# CITY OF PORTLAND BUILDING PERMIT

Job ID: 2012-08-4641-ALTCOMM

has permission to Add 12'x24' storage/exit & 7'x14' exit well. Break  
provided that the person or persons, firm or corporation accepting this permit shall comply with all of the provisions of the Statues of Maine and of the Ordinances of the City of Portland regulating the construction, maintenance and use of the buildings and structures, and of the application on file in the department.

SITE LAYOUT

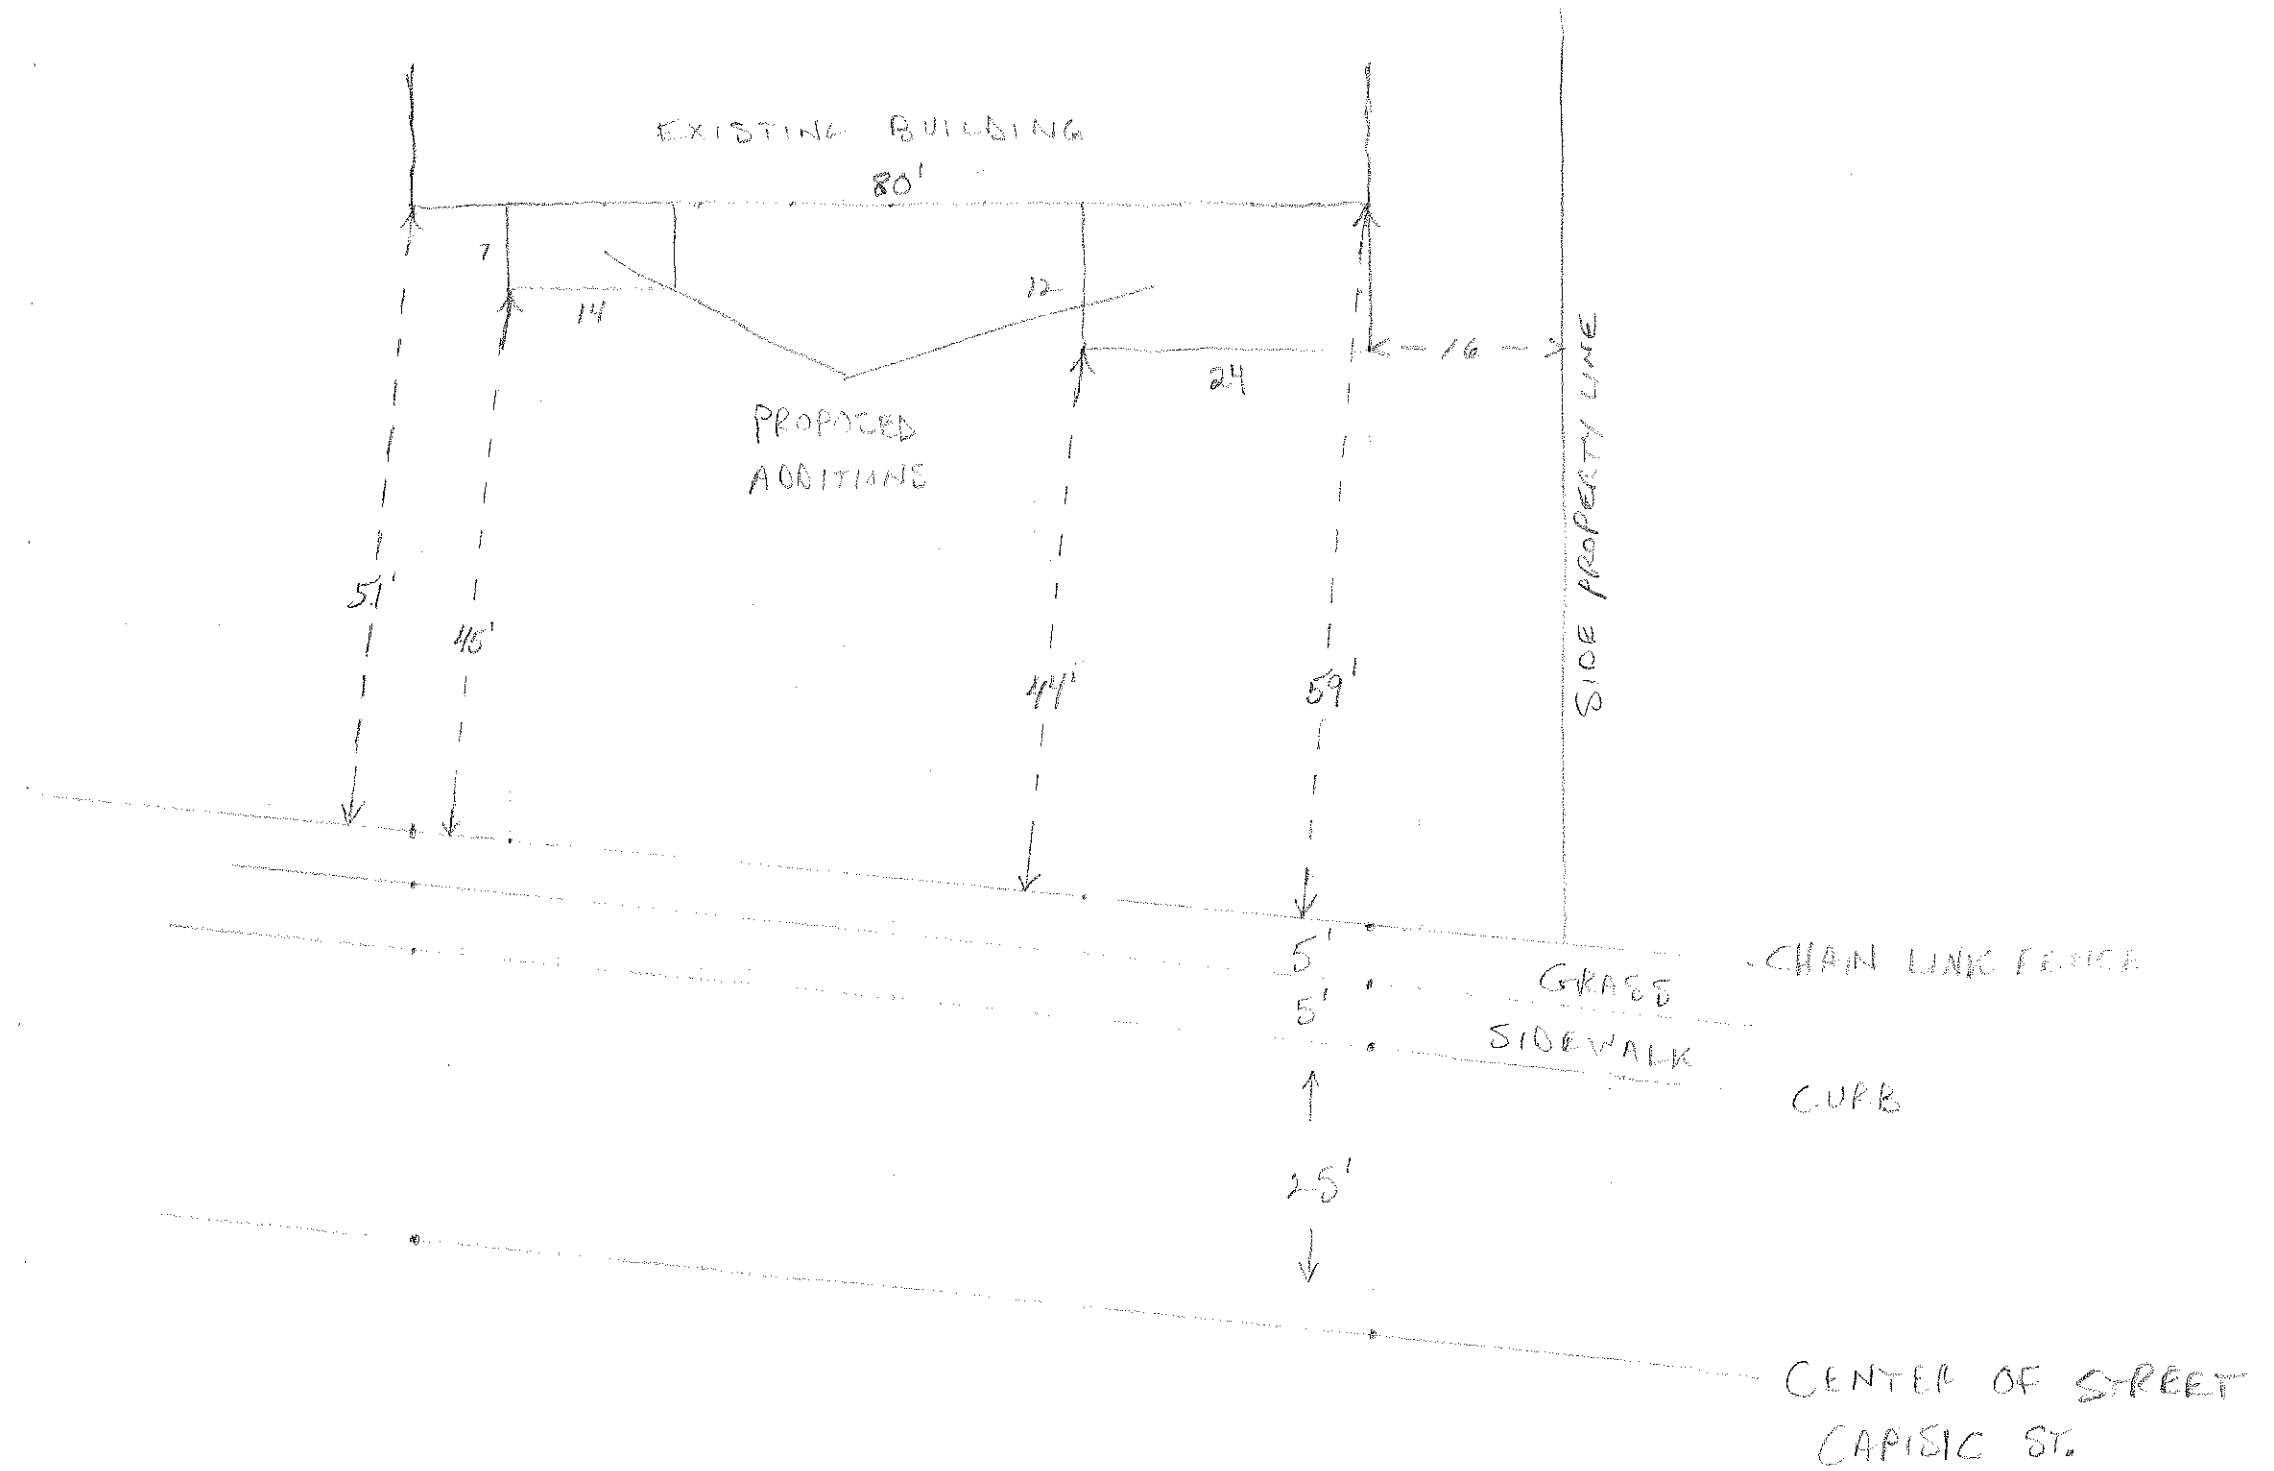
1. This permit is being approved on the basis of plans submitted. Any deviations shall require a separate approval before starting that work.
2. As discussed during the review process, the property must be clearly identified prior to pouring concrete and compliance with the required side setback of 8 feet must be established. Due to the proximity of the setback of the proposed 12' x 24' addition, it may be required to be located by a surveyor.

UNHEATED STORAGE ROOM + UTILITY ENTRANCE

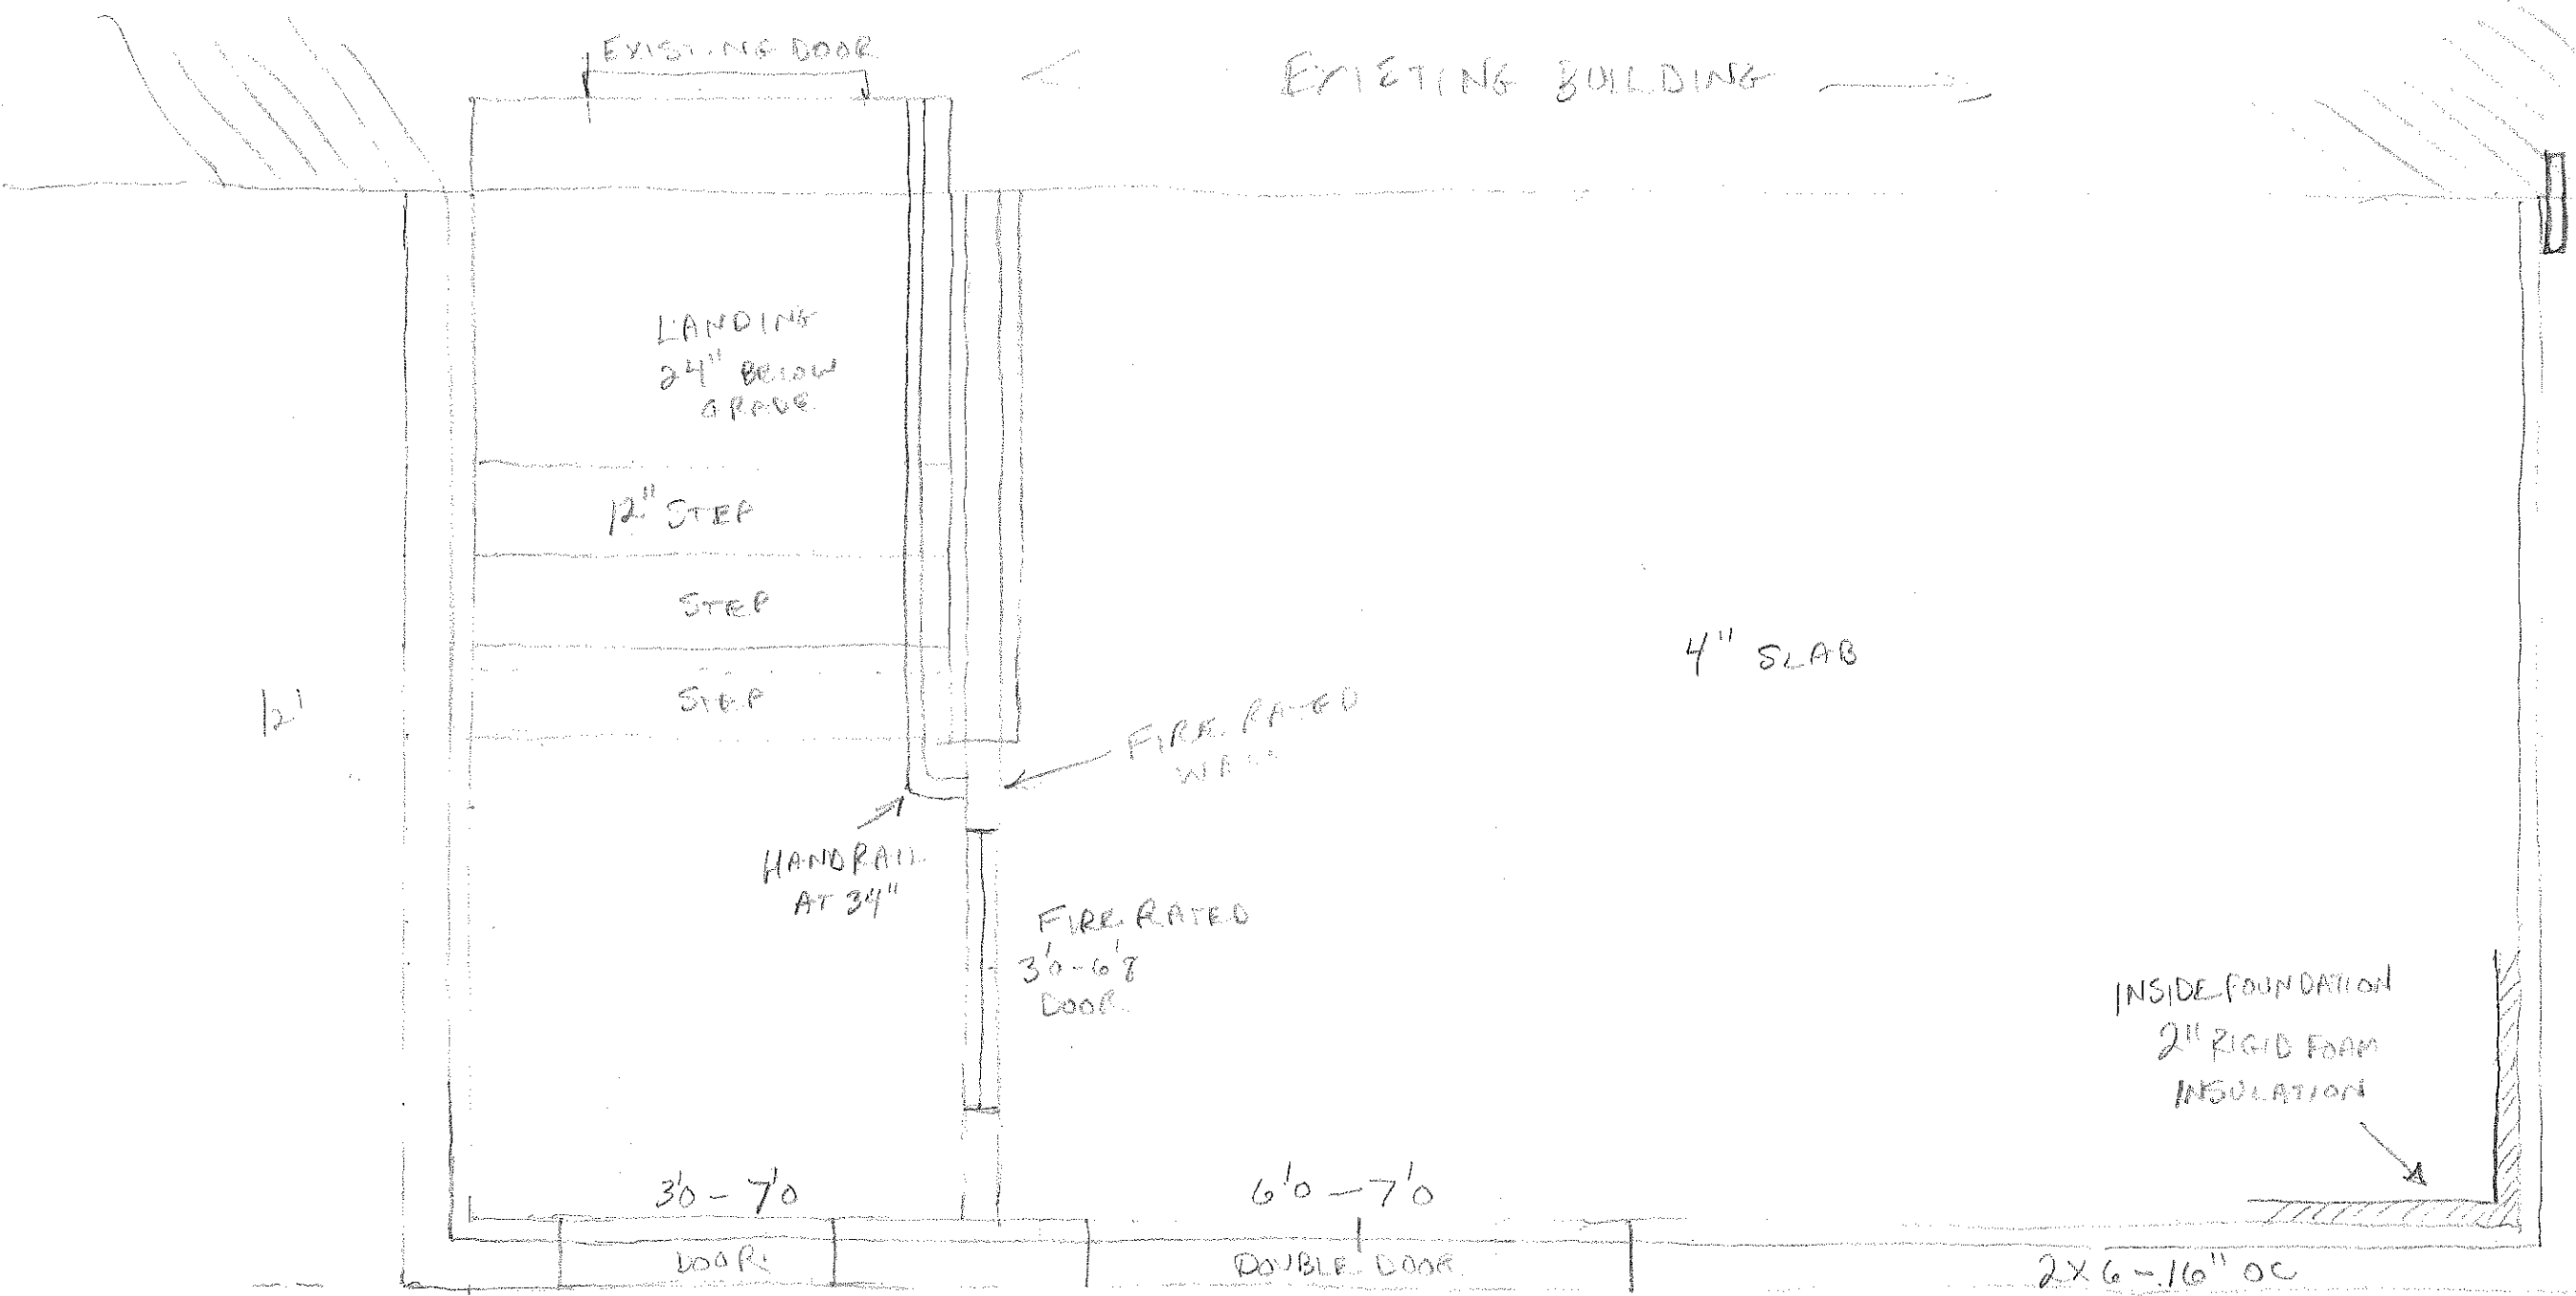
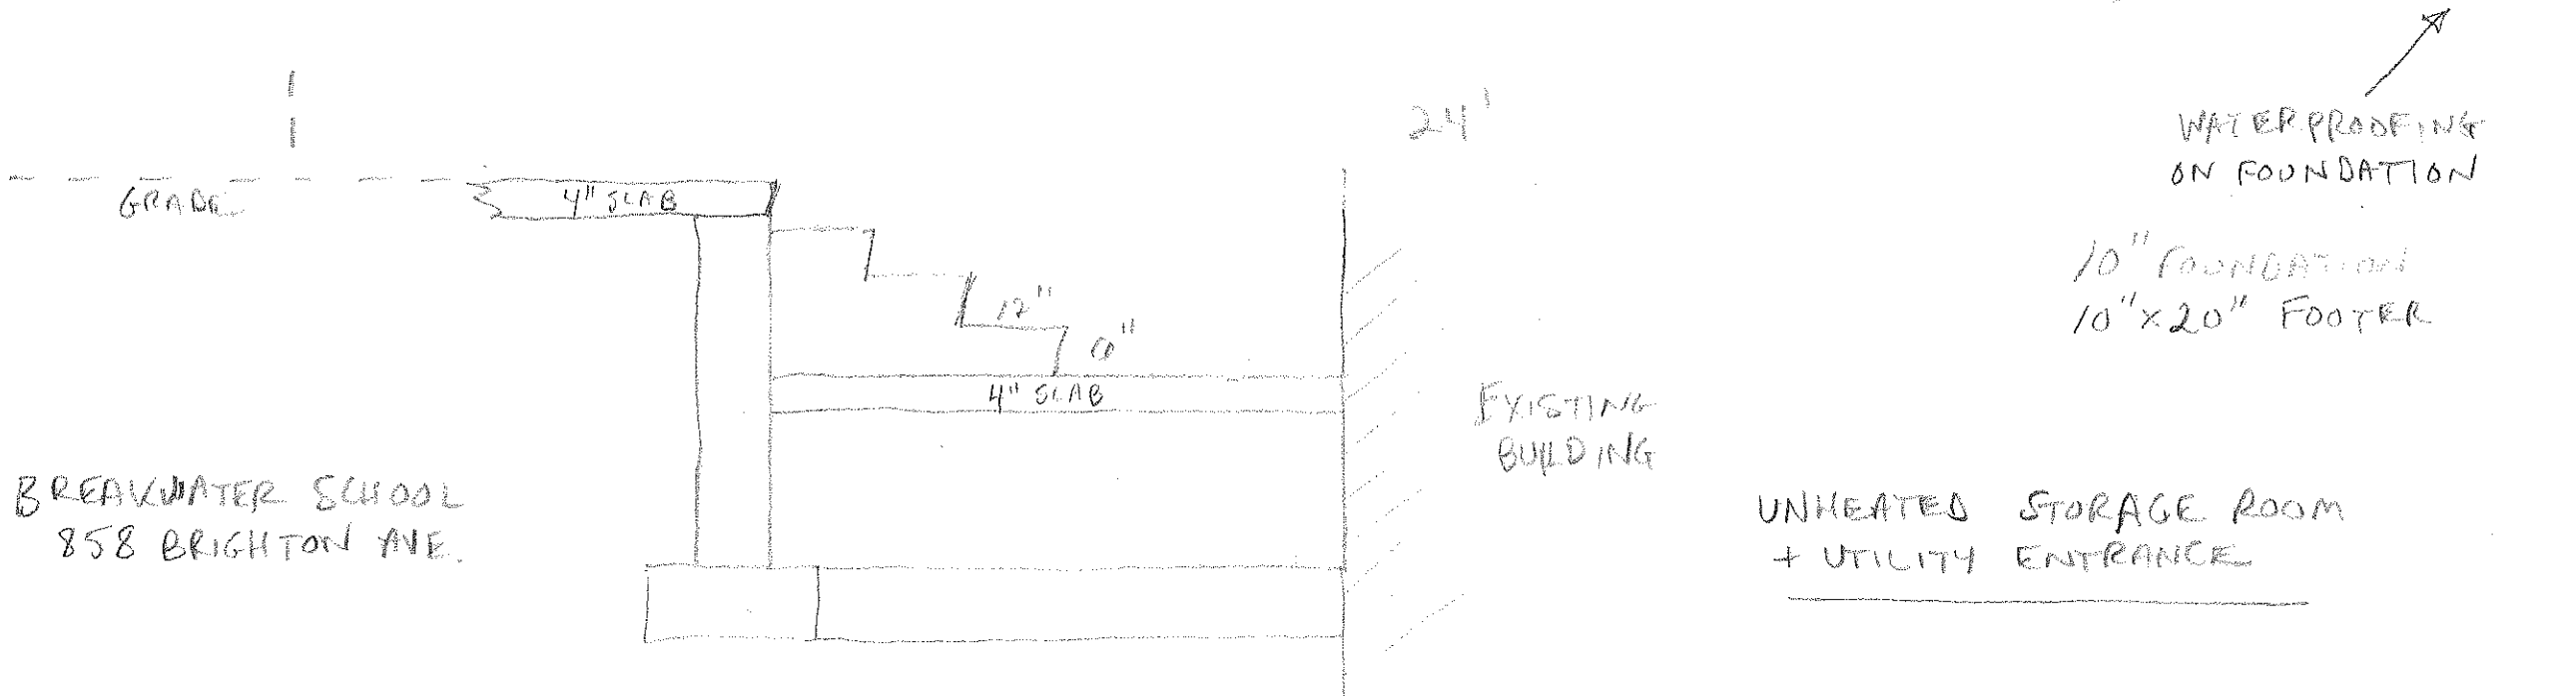
1. All construction shall comply with City Code Chapter 10.
2. Stairs, handrails and guards shall be in accordance with NFPA 101:7.2. Handrails are required on both sides of stairs. Guards are required for walking surfaces greater than 30" above the adjacent floor or ground.

17. Any cutting and welding done will require a Hot Work Permit from Fire Department.
18. Walls in structure are to be labeled according to fire resistance rating. IE; 1 hr. / 2 hr. / smoke proof.
